SUBJECT: Brownlee Short Plat SP-16-00004

RE: Brownlee SP-16-00004 Comment

RE: SP-16-00004

RE: SP-16-00004 Brownlee

BROWNLEE SHORT PLAT
PART OF SECTION 36, T. 17 N., R. 19 E., W.M.
KITITAS COUNTY, WASHINGTON

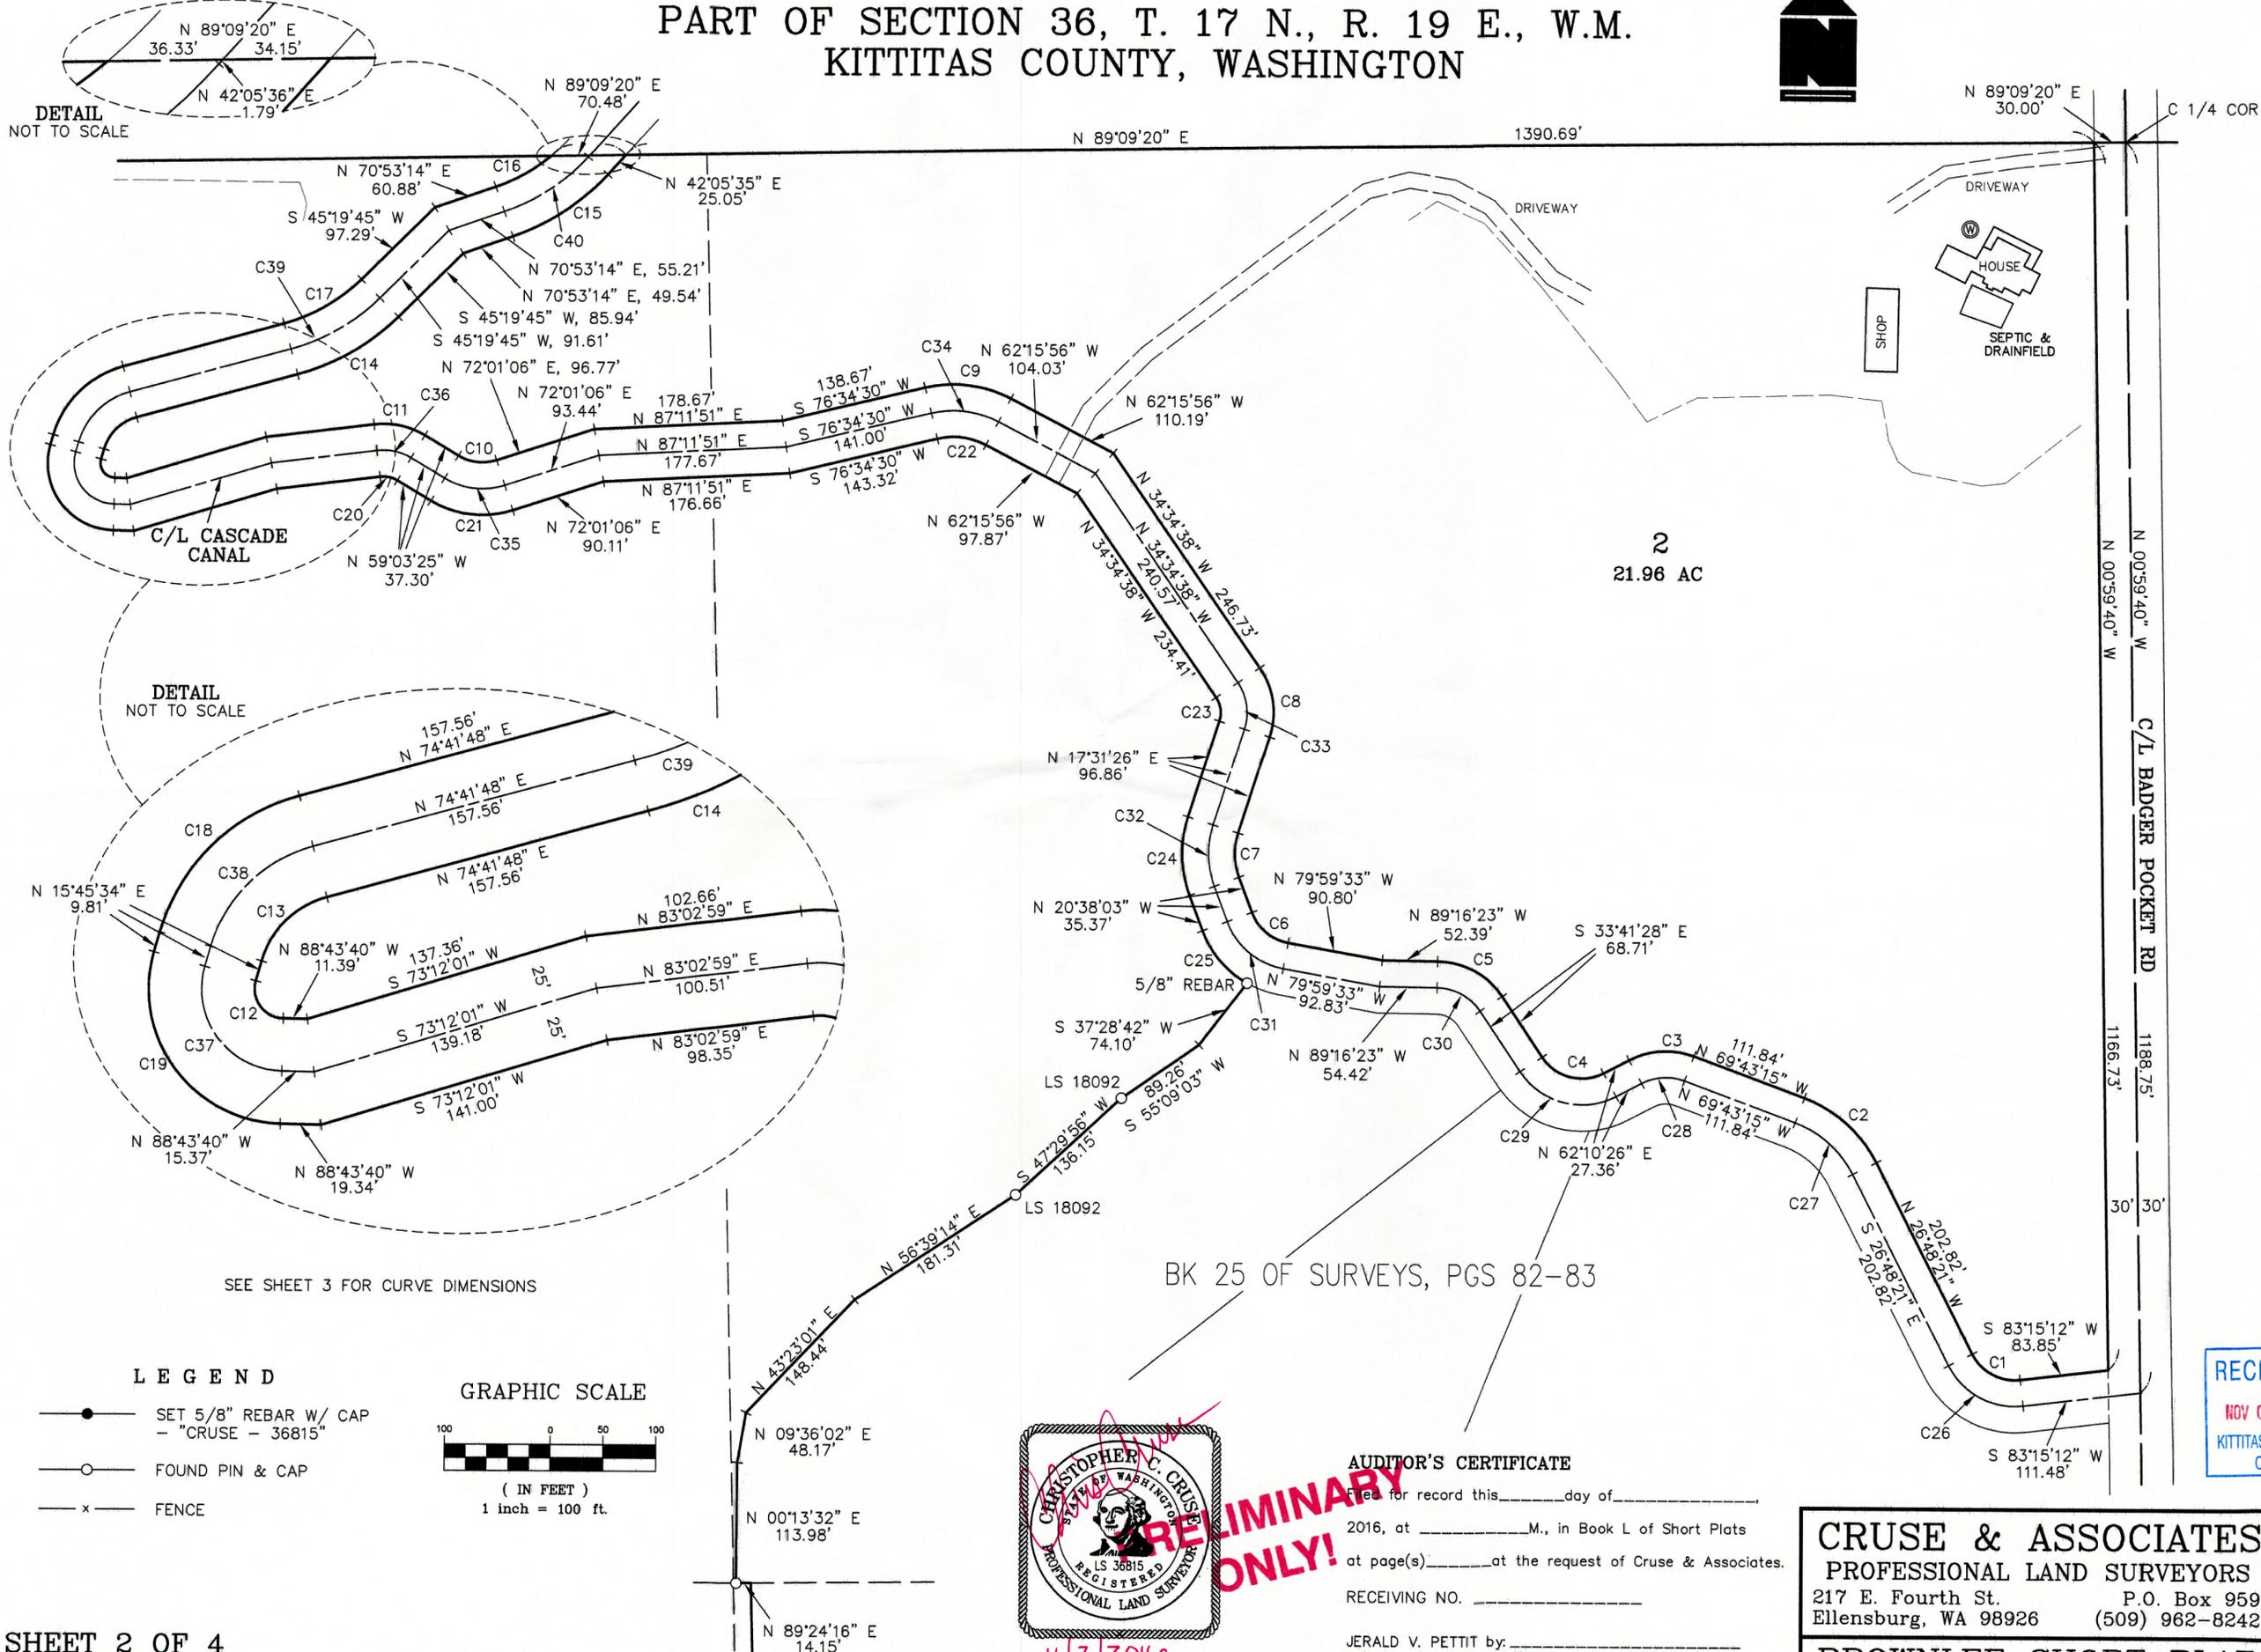
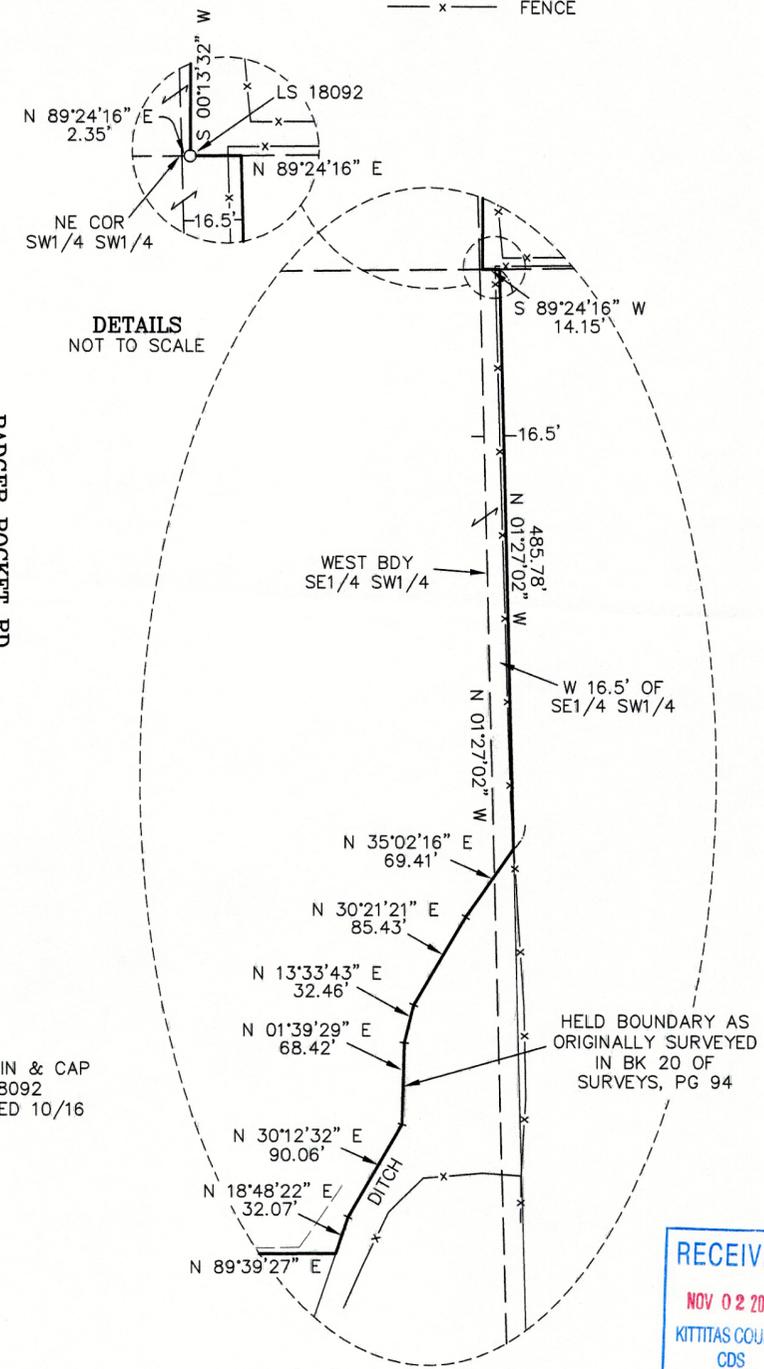
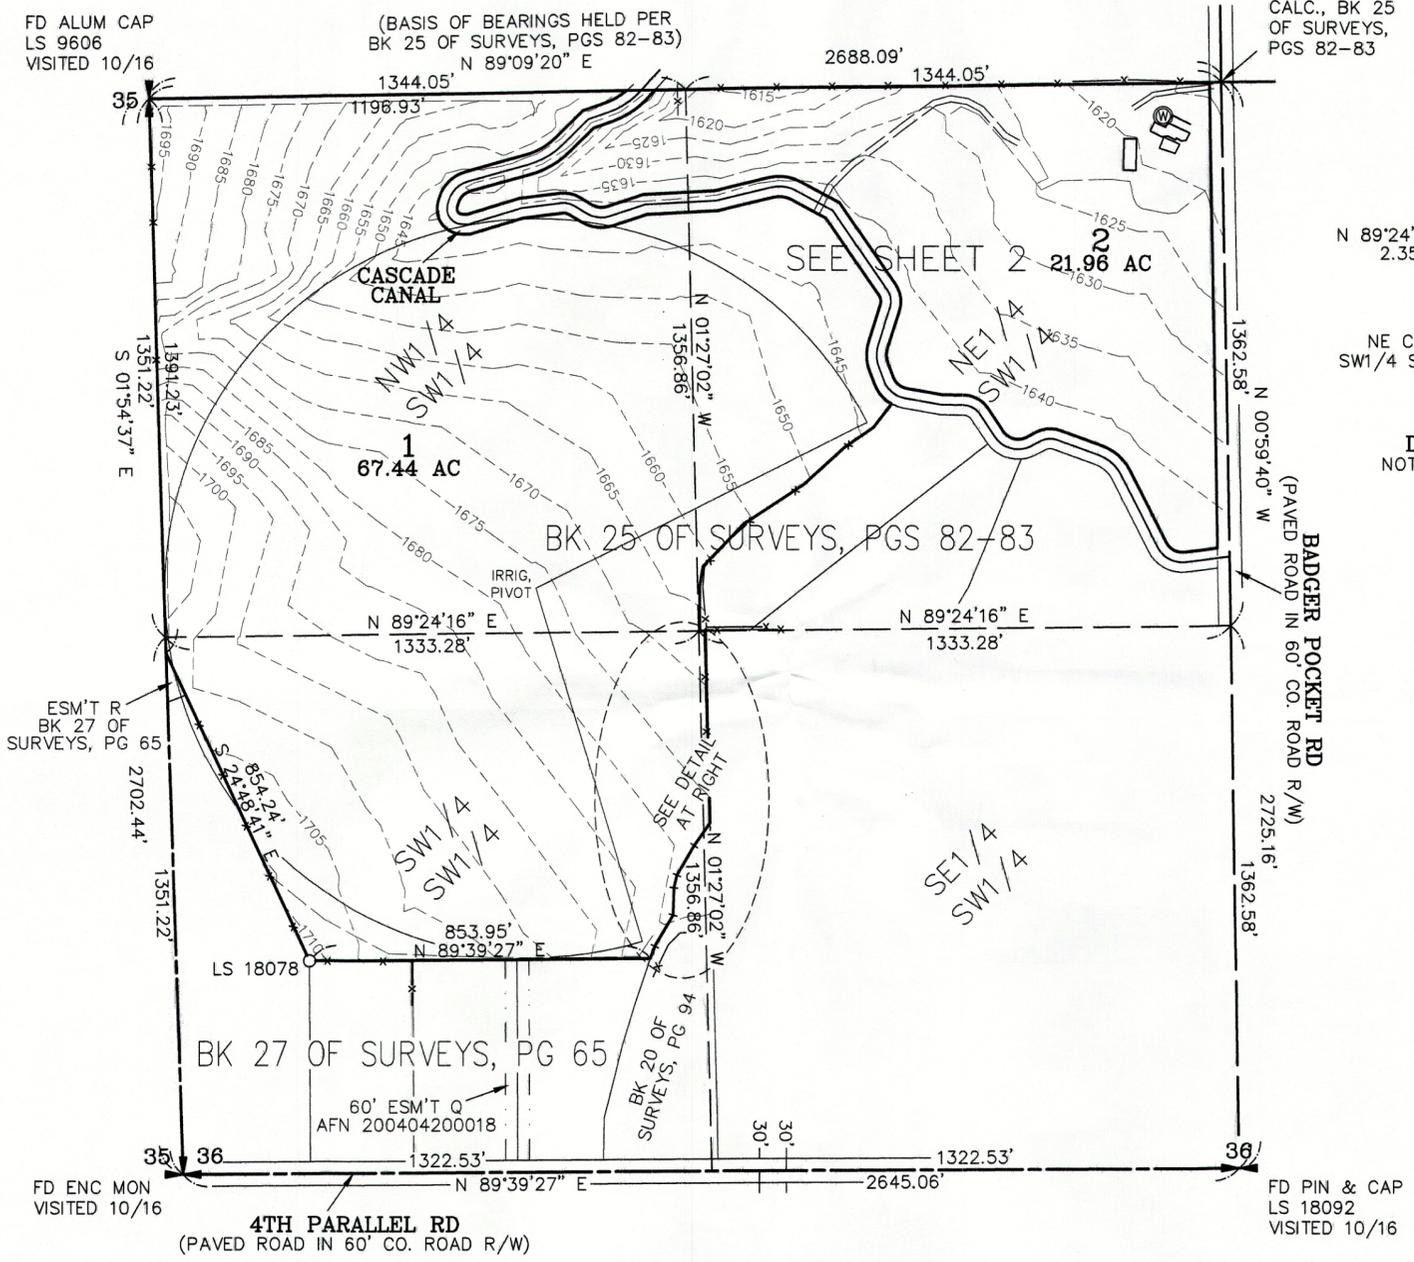
1. Transportation Concurrency: Is required on all divisions of land prior to final approval.
2. Access to Lot 1: The existing 60' Easement Q located off of 4th Parallel Road is for agricultural use only. An access driveway for the property will need to be established either by amending the existing agricultural easement to allow for all uses, or through a joint use driveway easement across lot 2. The access easement must be shown on the face of the short plat.
